FG/196/17/NMA

Application for a non-material amendment following a grant of planning permission.

AMENDMENT TO FG/136/17/HH WITH ALTERATION TO FRONT PORCH

ENCLOSED PORCH TO REPLACE PROPOSED CANOPY

PROPOSED FRONT ELEVATION

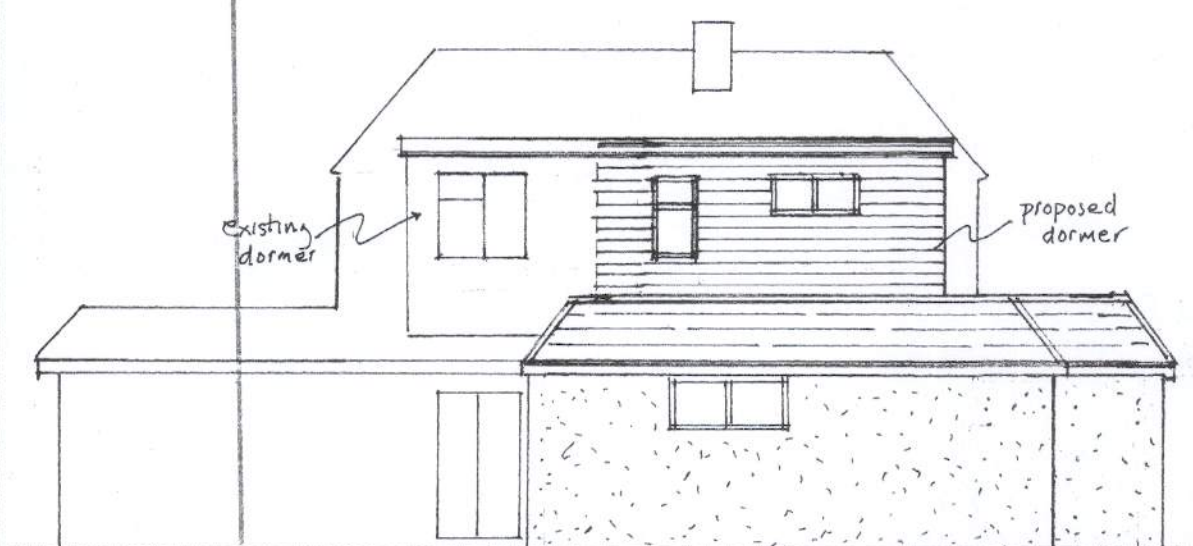
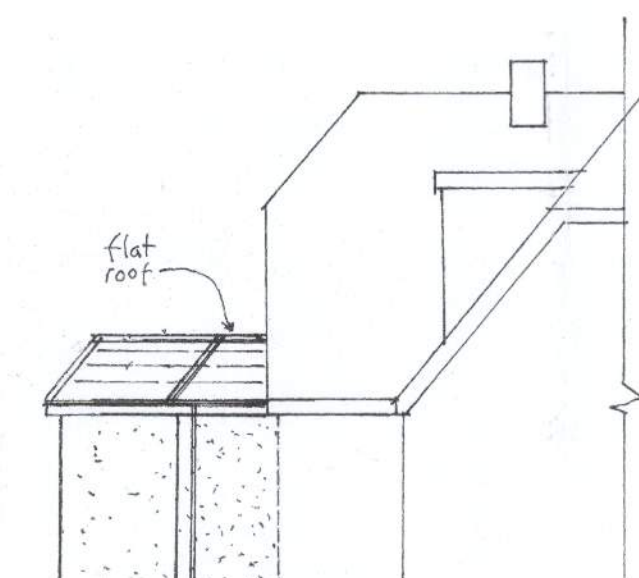
TO ENCLOSE PORCH AT FRONT
